RE: Transmittal of Comments – Stone Short Plat (SP-08-00043)

RE: Stone Short Plat (SP-08-00043)

TO: Jeff Watson, Community Development Services
FROM: Christina Wollman, Planner II *CW*
DATE: October 27, 2008
SUBJECT: Stone Short Plat SP-08-43

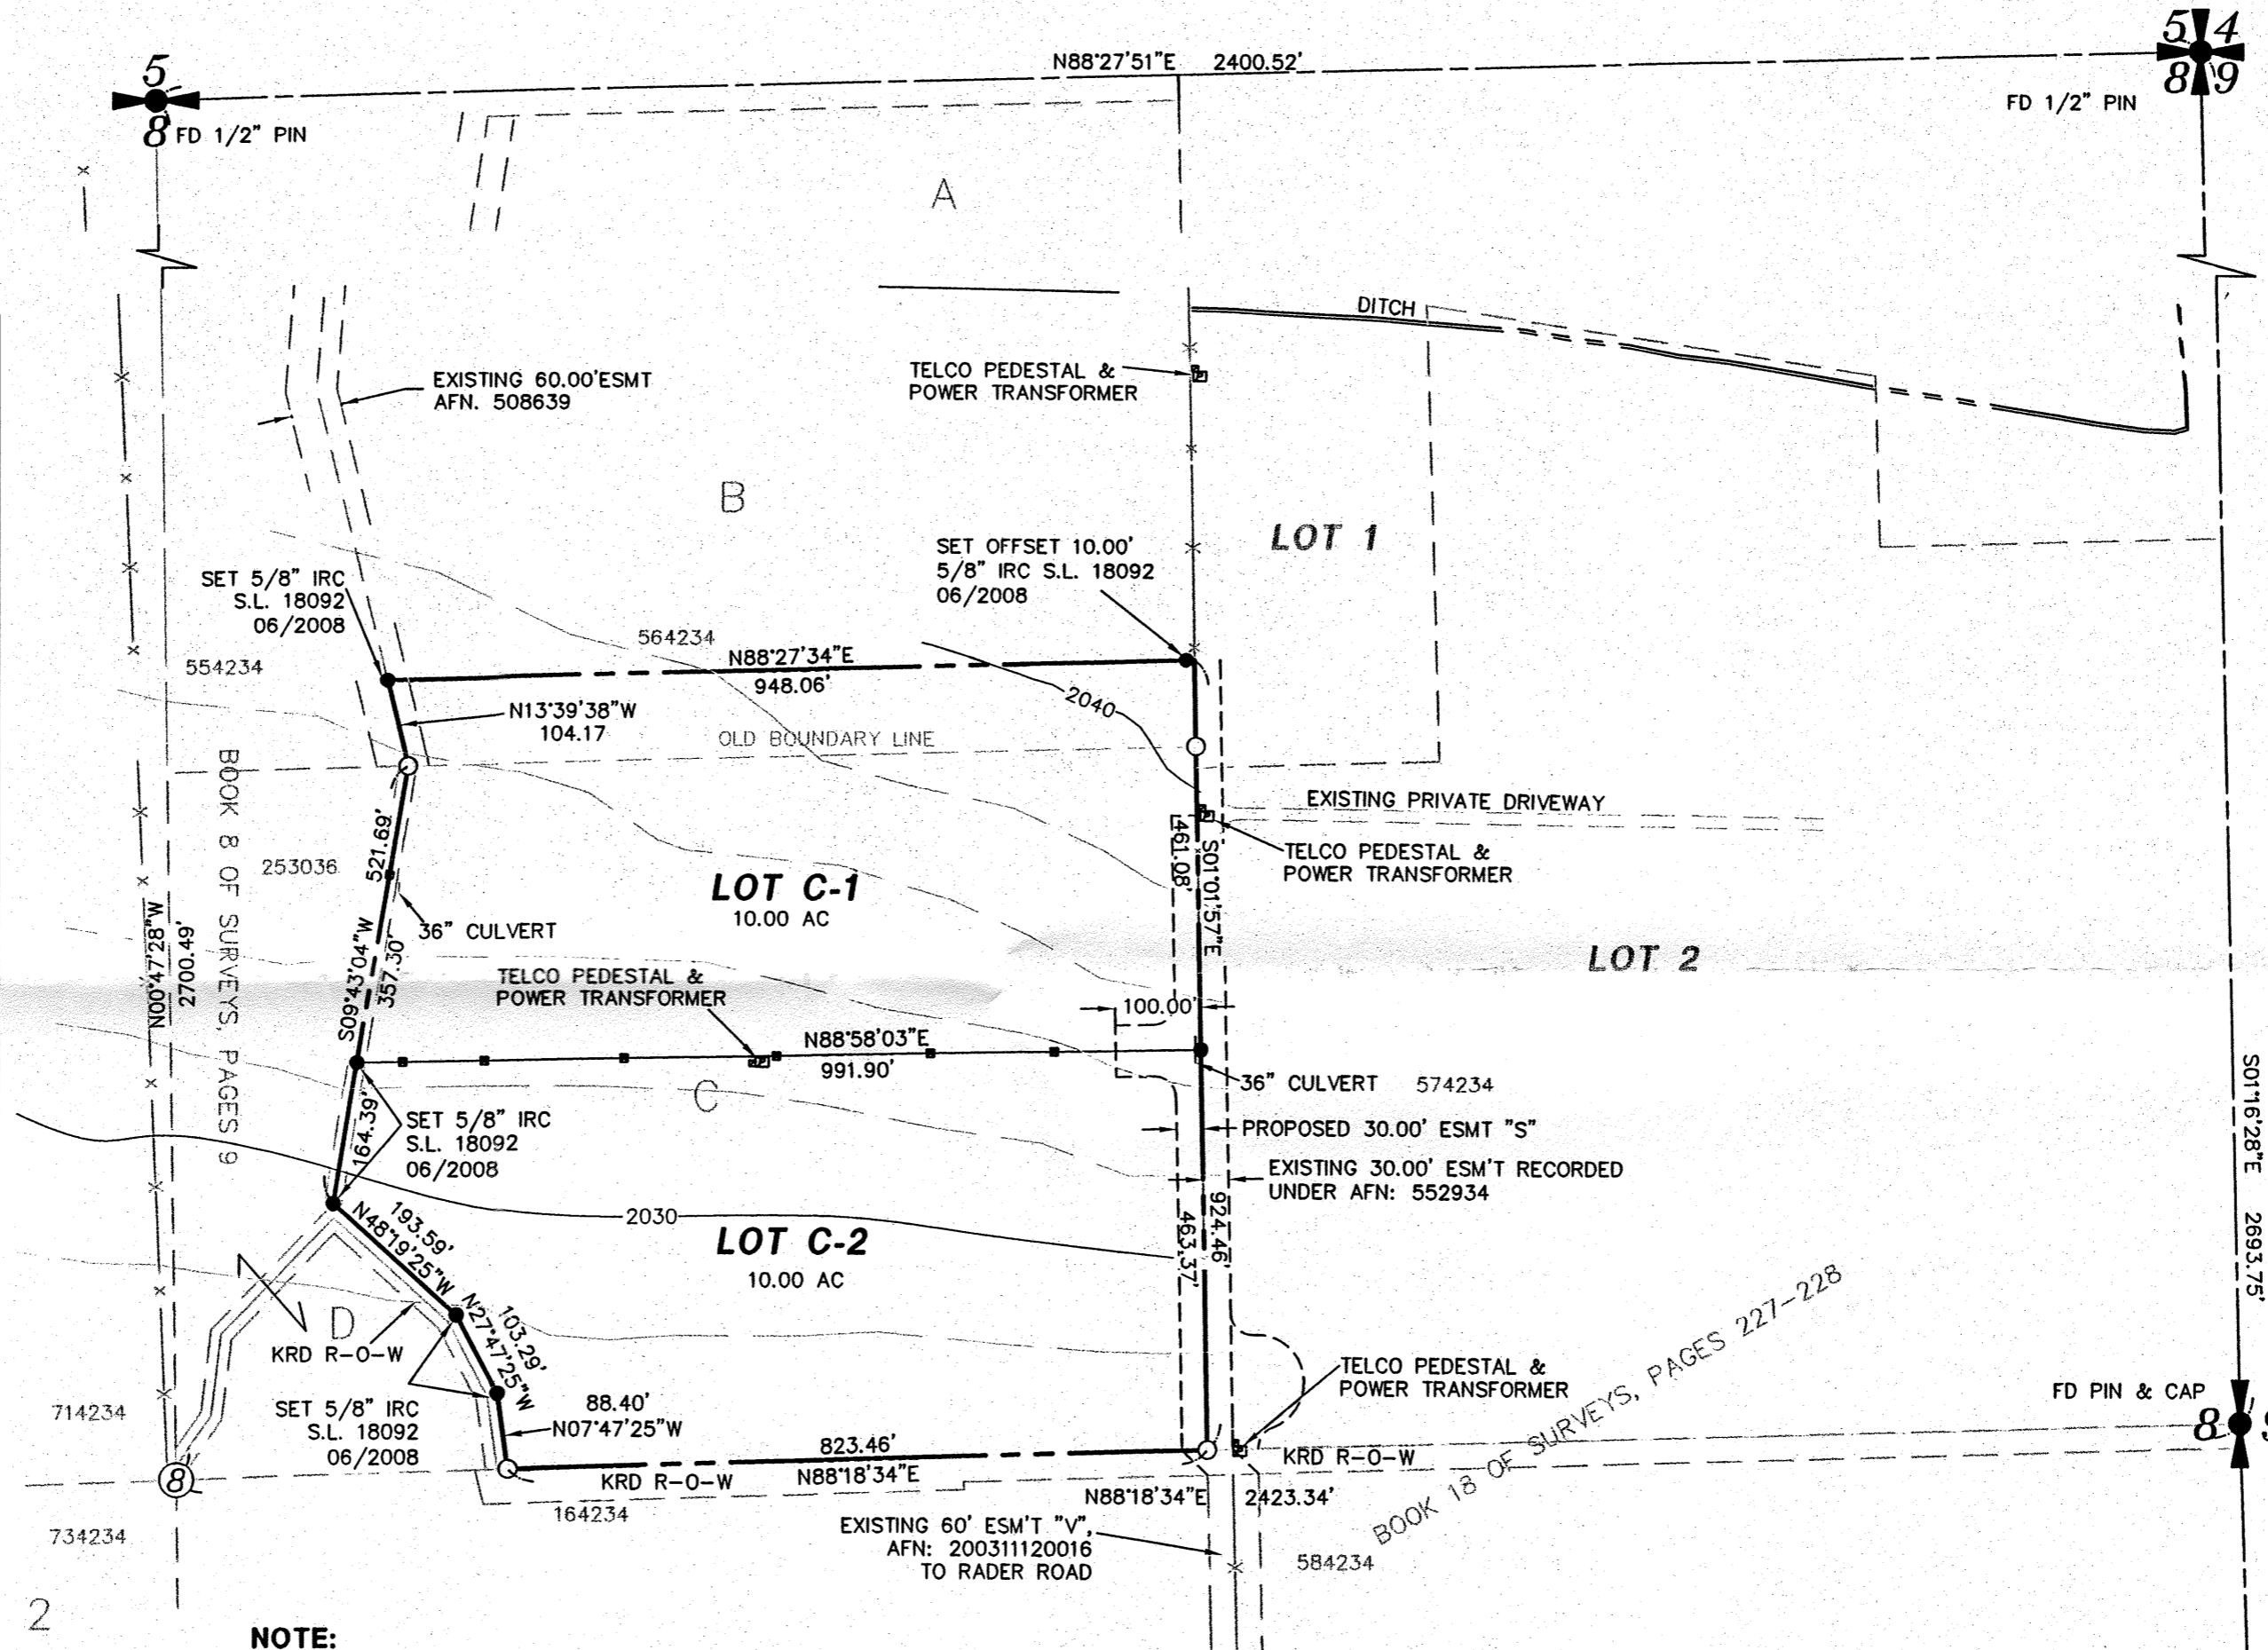
- Please have the applicant re-submit the plat drawing to reflect the location of the existing well.

2. Access Easements: Auditors Filing Numbers for all access easements shall be shown on the plat. The access easement shall be shown in its entirety to the intersection with Rader Road either on the plat face or clearly shown in the vicinity map.

3. Road Name: Prior to final approval, the access road shall be named and the private road name shown on the face of the plat.
4. Private Road Improvements: Access from Rader Road to the hammerhead shall be constructed as a Low-Density Private Road. See Kittitas County Road Standards, 9/6/05 edition.

- a. Access easements shall be a minimum of 60' wide. The roadway shall have a minimum width of 20', with 1' shoulders, for a total width of 22'.
 - b. Minimum centerline radius will be 60'.

5. Turnaround: Because a cul-de-sac turn-around will be constructed near the southeast corner of this property by a neighboring plat, a hammerhead turnaround will be allowed as shown on the short plat. Turnarounds must conform to the requirements specified by the 2006 International Fire Code. Contact the Fire Marshal regarding any additional turnaround requirements.
